Rezoning Transportation Analysis

Petition Number: Zoning Petition #2021-004

General Location Identifier: Tax ID 08117410

Reviewer: Walta Blackmon, PE
Walta.Brumskine@charlottenc.gov
704-432-6511

A100

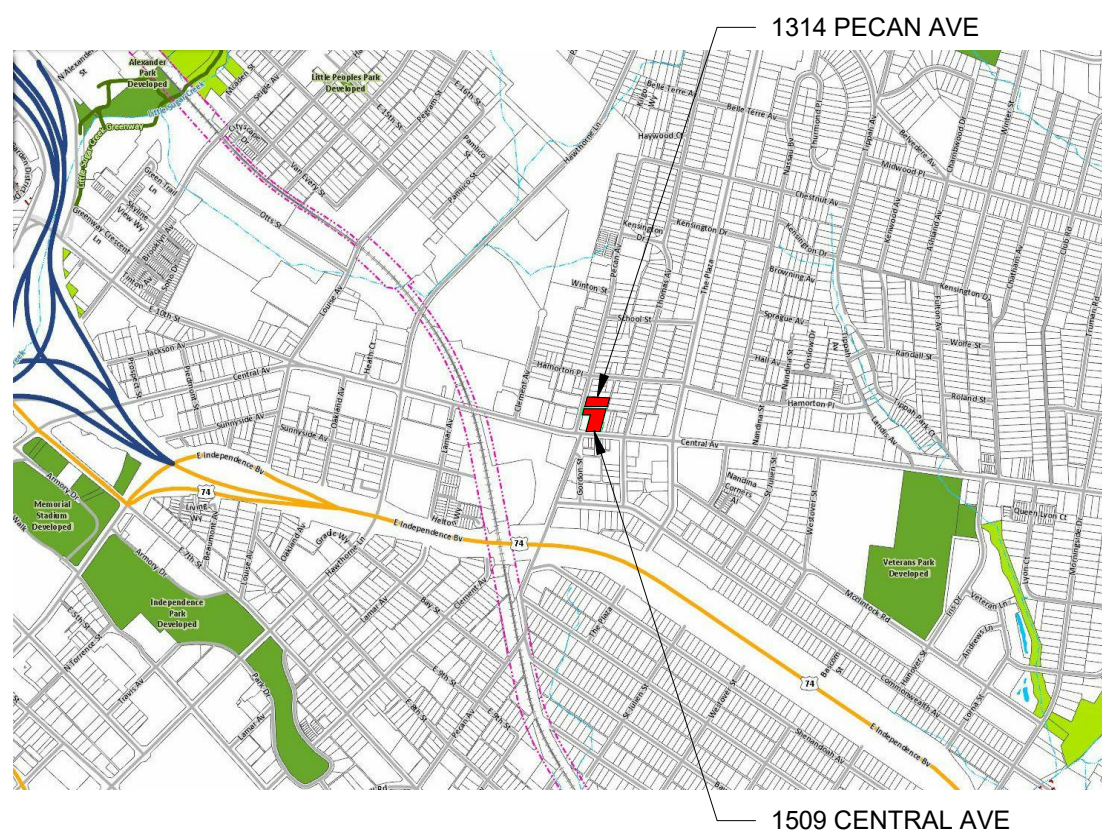
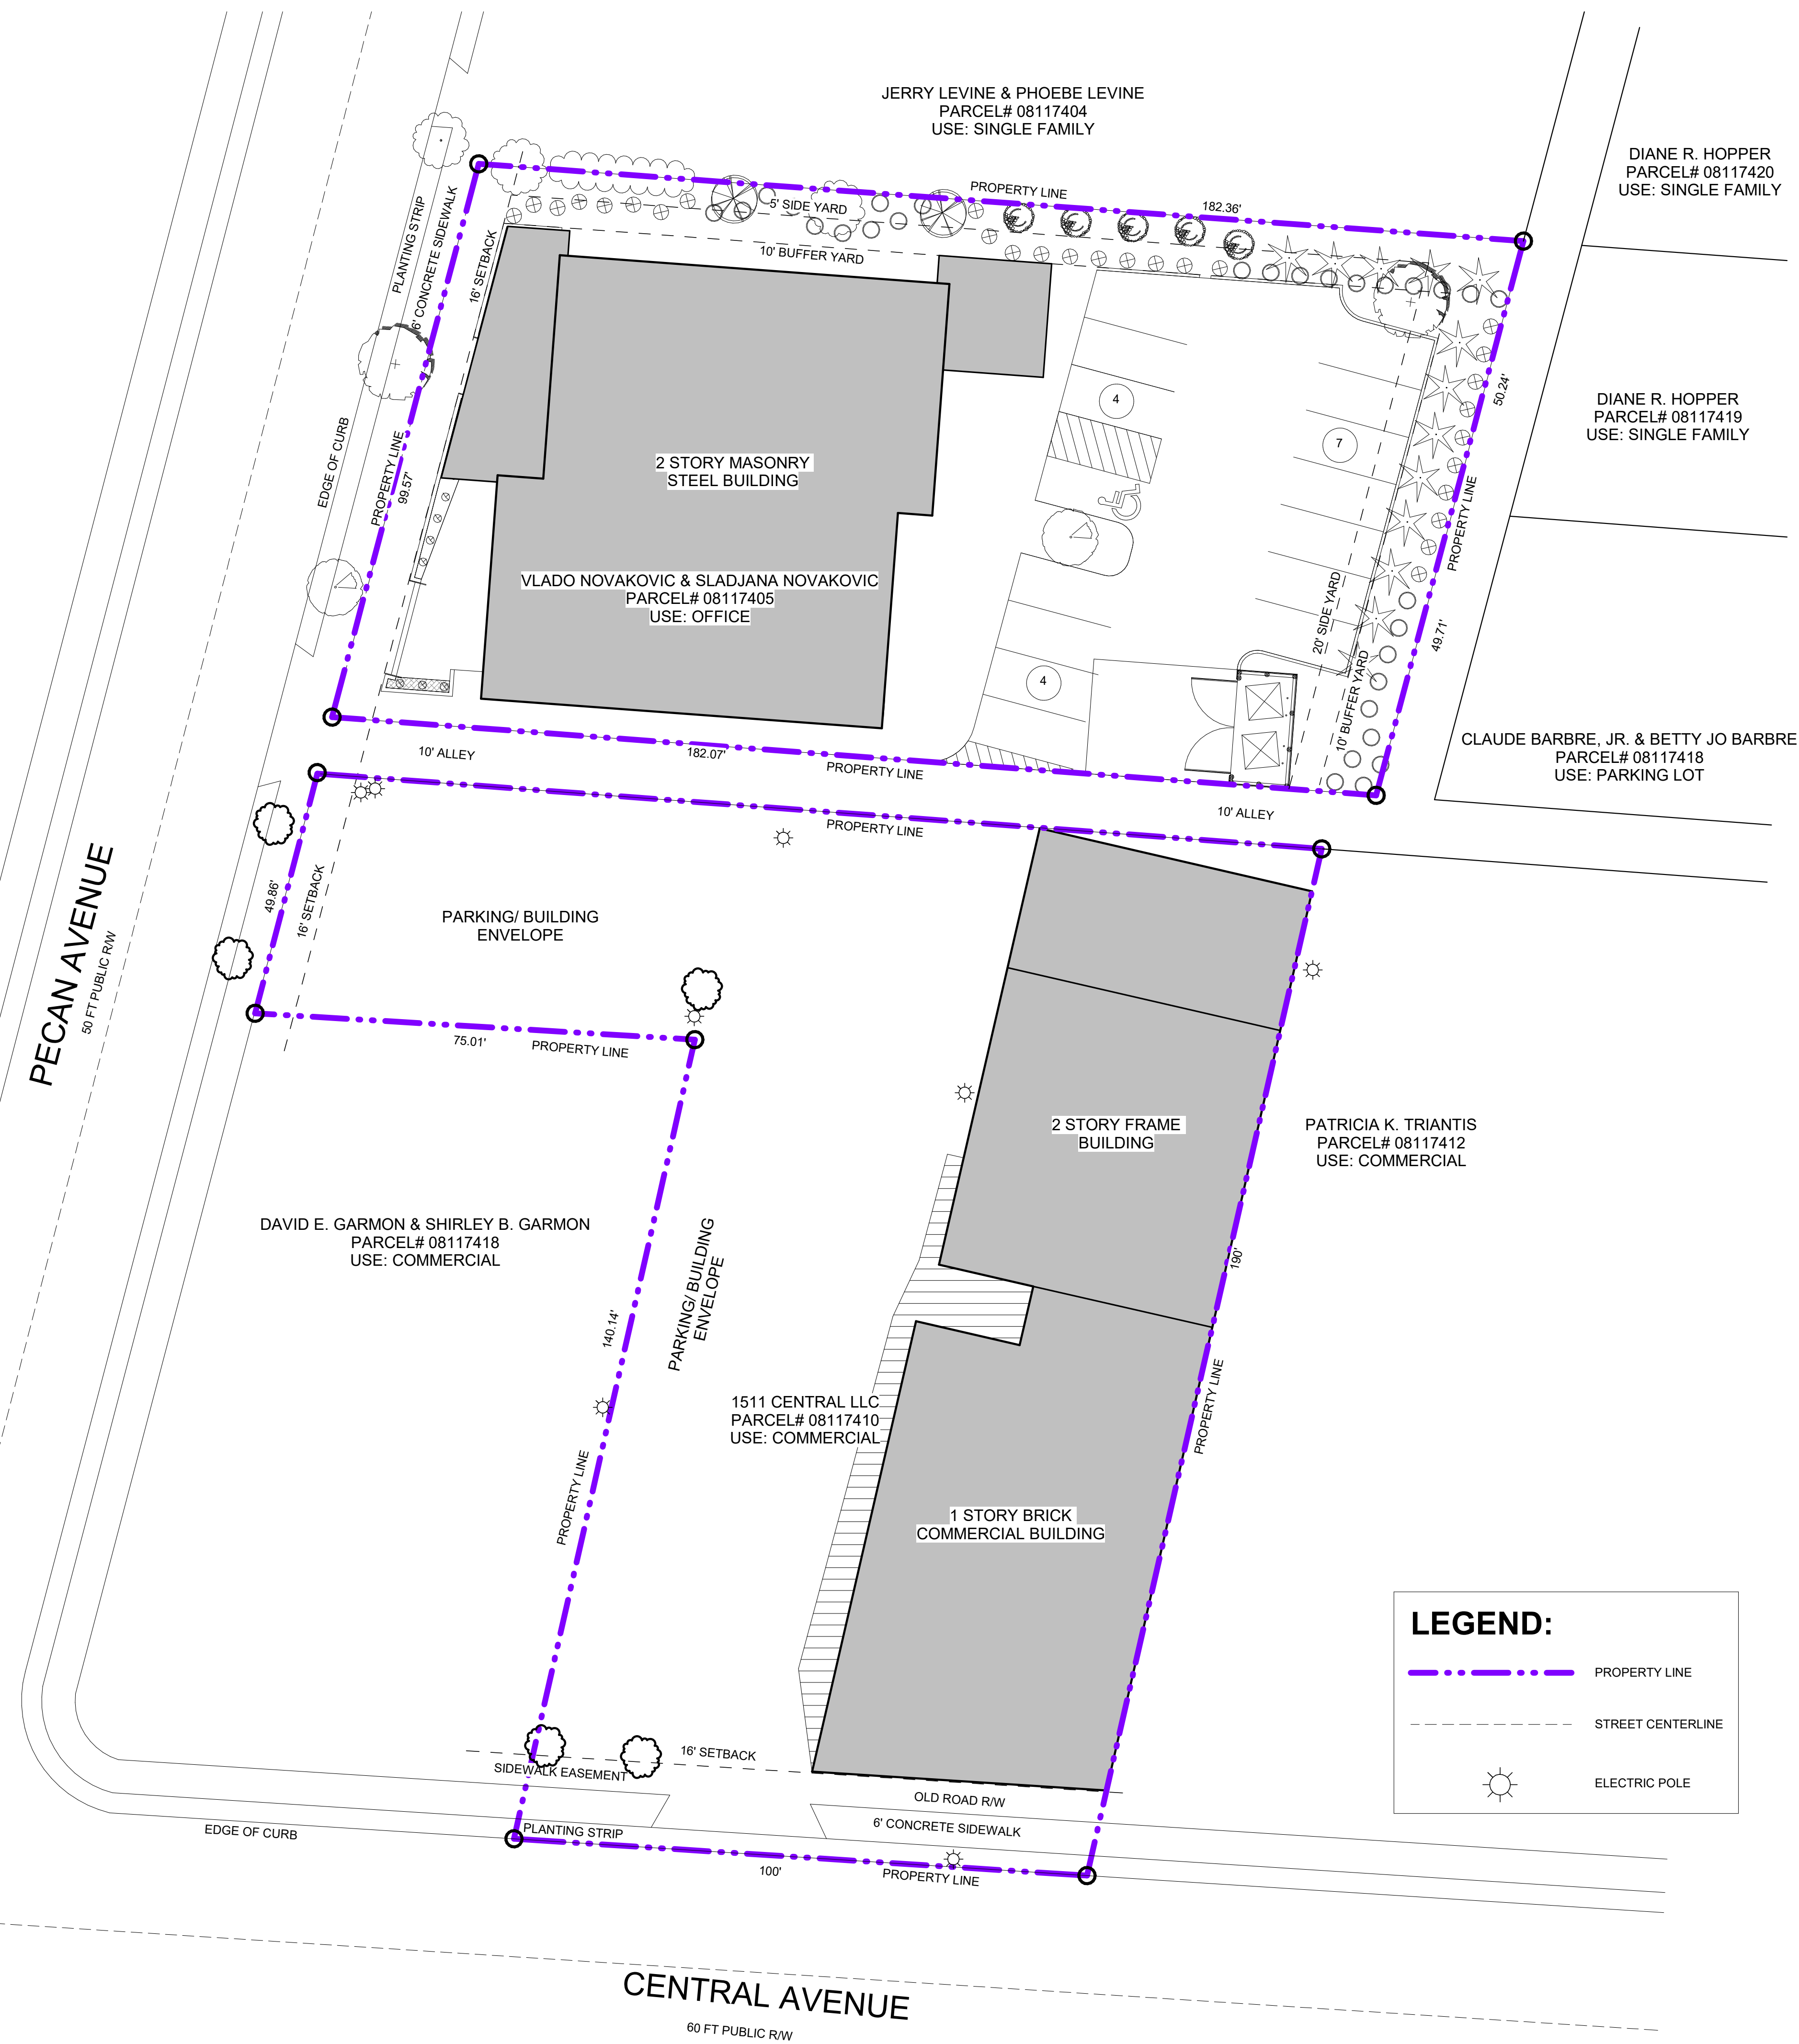
Label and dimension the existing curb and gutter from the centerline for each road on the site plan.

- Revise site plan and conditional note(s) to commit to providing a 15' sidewalk at the back of curb on Central Avenue, per Chapter 19 and the Plaza-Central Pedscape Plan. The site plan shall label and dimension the sidewalk from the back of curb and gutter.

- Revise site plan and conditional note(s) to commit to construct an 8-foot planting strip, and an 8-foot sidewalk on Pecan Street per Chapter 19, CLDSM U-05A and the Plaza-Central Pedscape Plan. The site plan shall label and dimension both items from the back of curb and gutter.

Revise site plan Conditional Note II.d. to the following: "To not require the installation of streetscape improvements along Central Avenue when change of uses or building expansions occur if Chapter 19 is not triggered. Should a future building expansion trigger Chapter 19 requirements, pedestrian and drainage facilities will be required."

7. Add a site plan note specifying dedication and fee simple conveyance of all rights-of-way to the City before the site's first building certificate of occupancy is issued is needed. CDOT requests rights-of-way set at 2' behind back of sidewalk where feasible.
8. Add a site plan note specifying that all transportation improvements will be approved and constructed before the site's first building certificate of occupancy is issued is needed. The petitioner may phase transportation improvements if said improvements and phasing are explicitly described in site plan notes.
